Project Name: 267 Congress St.; Conditional Use and Site Plan

Project Description: Conditional Use for Chaim Synagogue Single Story Addition & Exterior stair addition

Subject: Application ID: 2012-556

Comments Submitted by: Marge Schmuckal/Zoning on 2/15/2013

Drawing file: 1. Original Plans / C1.001.Boundary Survey.pdf

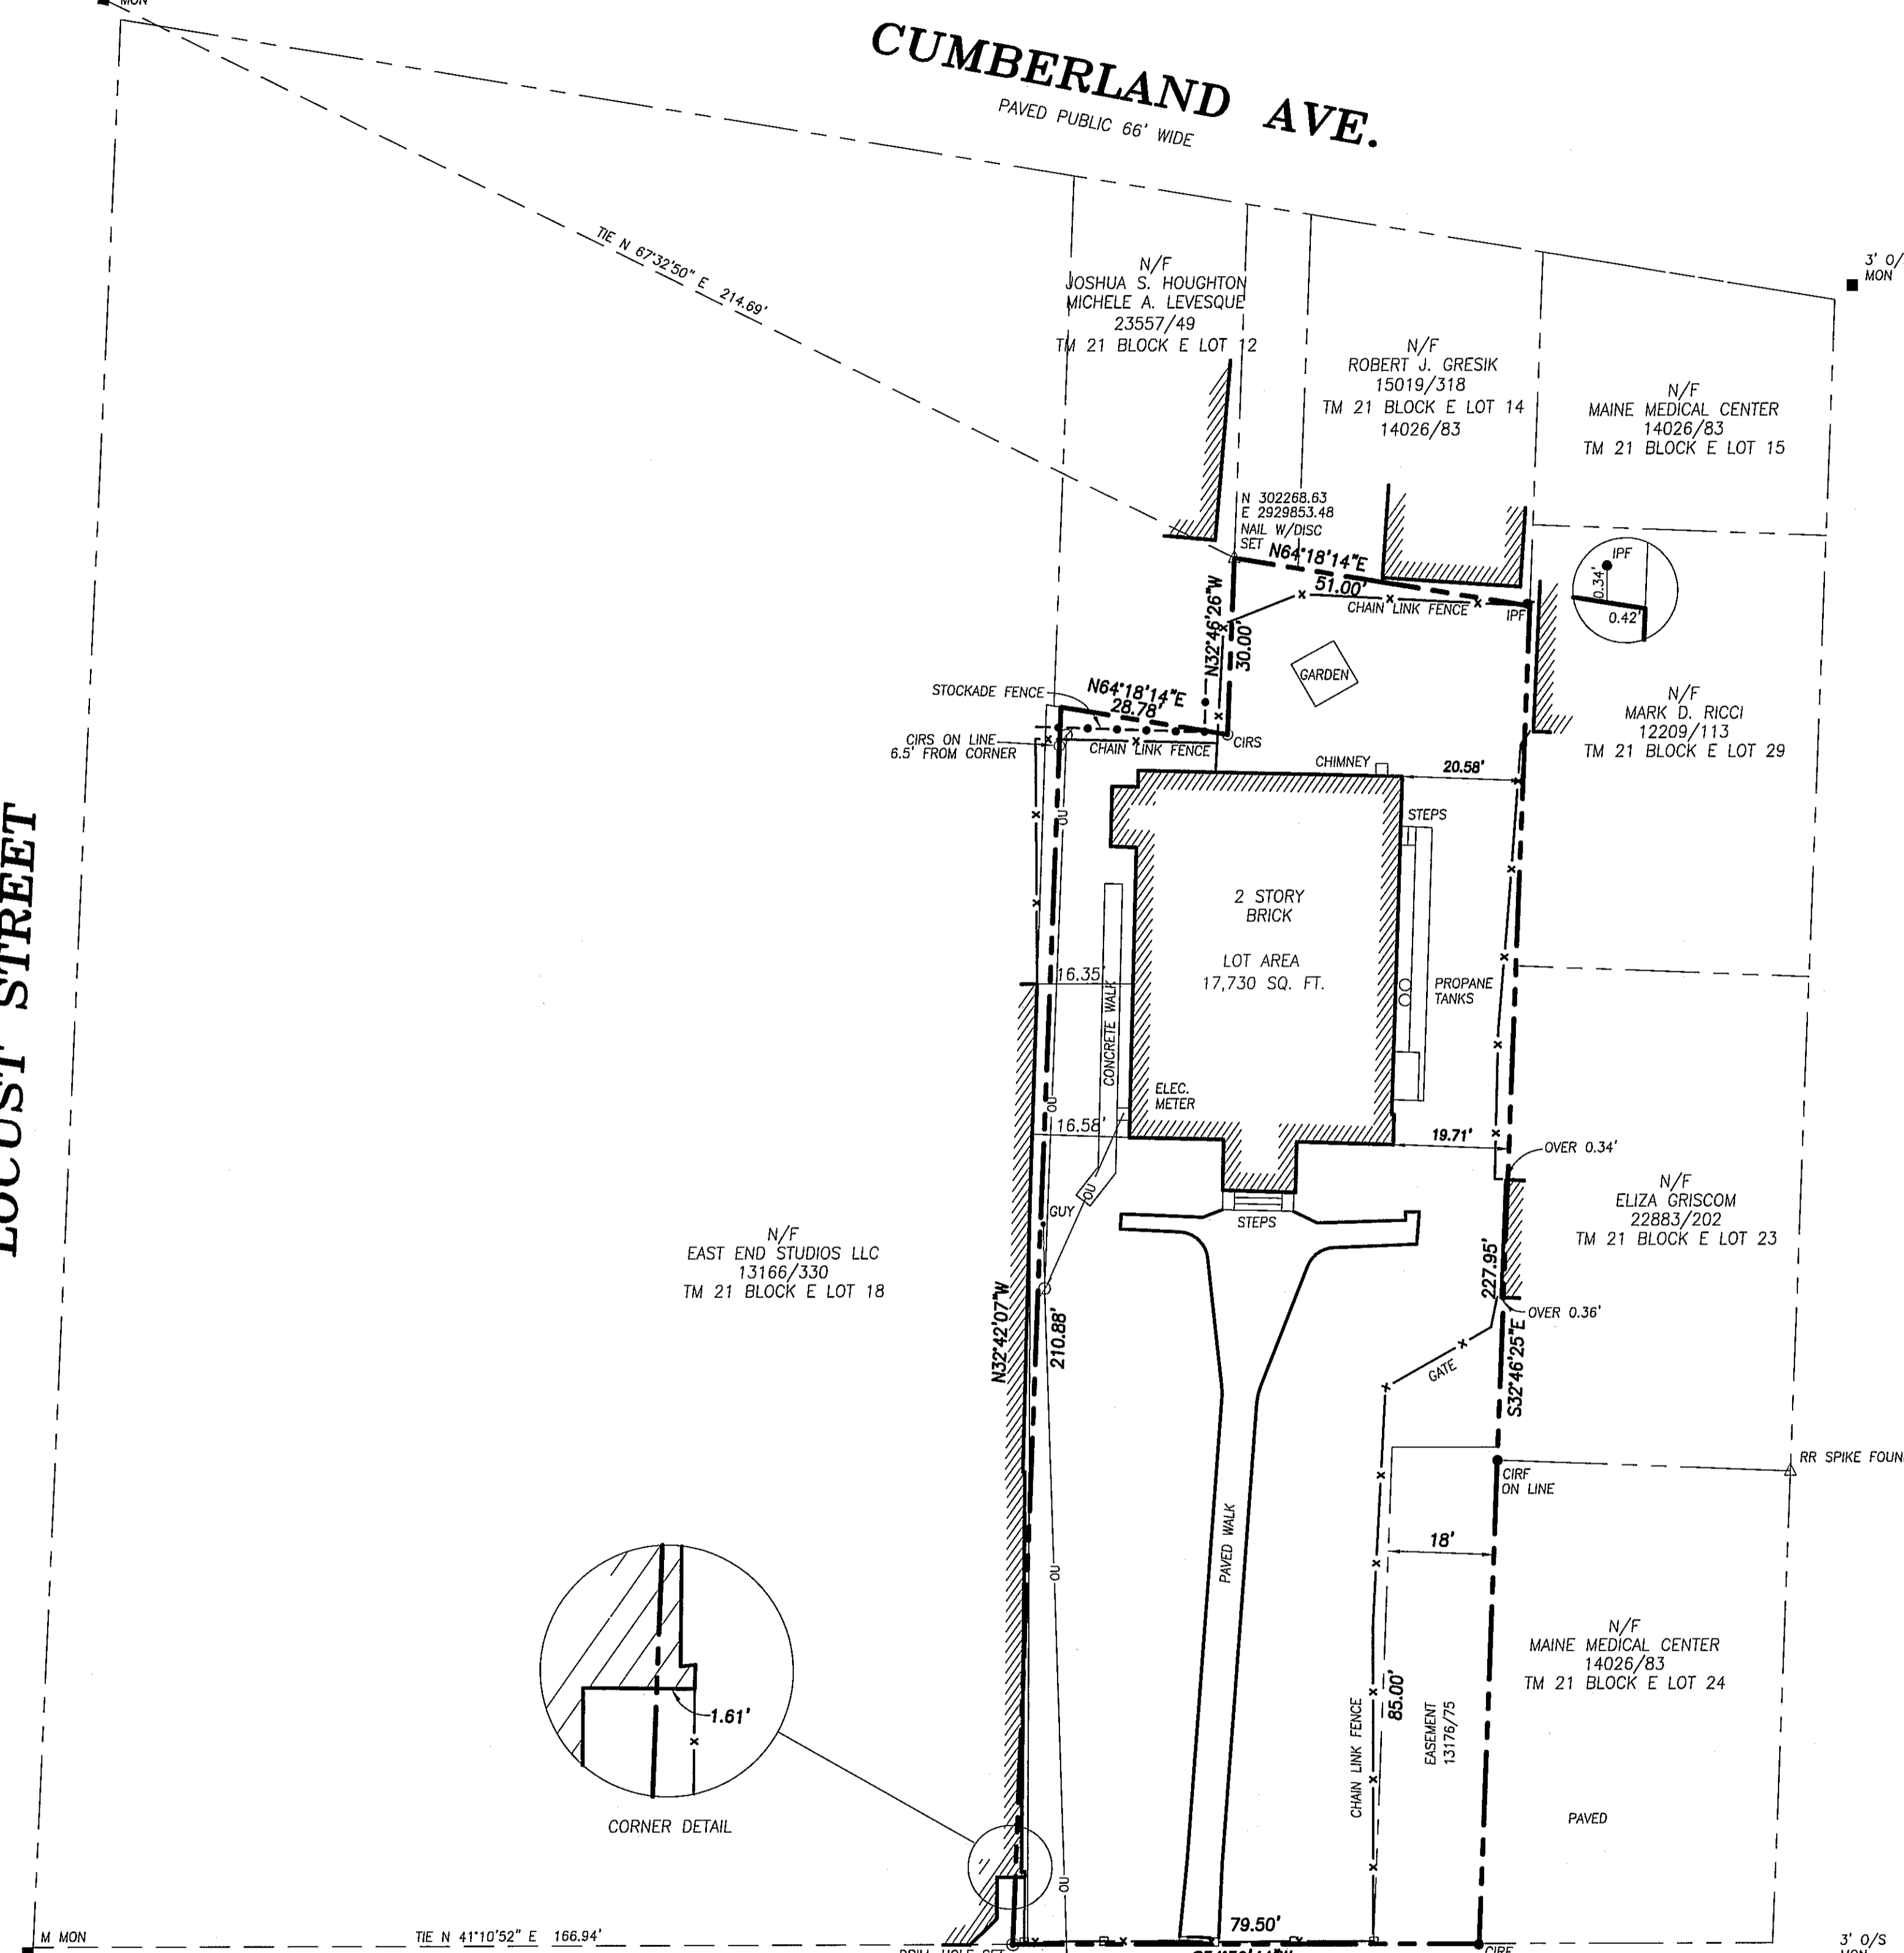
On 1/23/2013 I received revised plans for the synagogue. Those new plans revised the size of the additions especially the addition on the western side of the building. The plans show the addition to be 5.2' instead of the previous approximate 2 foot at the closest point to the existing property line. That revision allows me to us to approve the project without an appeal using 14-433. An appeal to the Zoning Board of Appeals is not required. So lam approving the 5.2 foot setback.

At the end of last week I received an appeal application for a setback variance for 267 Congress Street. It appears that they reworked their project and lessened the size of the side addition. Now their side setbacks are 5.2' & 5.3' to the existing side property line. That doesn't require an appeal, Section 14-433 allows me to grant a setback of not less than 5'. So I will be putting together a new zoning memo to you reflecting that change. This still will need a conditional use appeal for the expansion of their Institutional use.

At this time I am unable to complete a zoning assessment based on required information concerning the proposed property line relocation. Without documentation of the new property line, this project is not meeting the setback requirements of the R-6 zone.
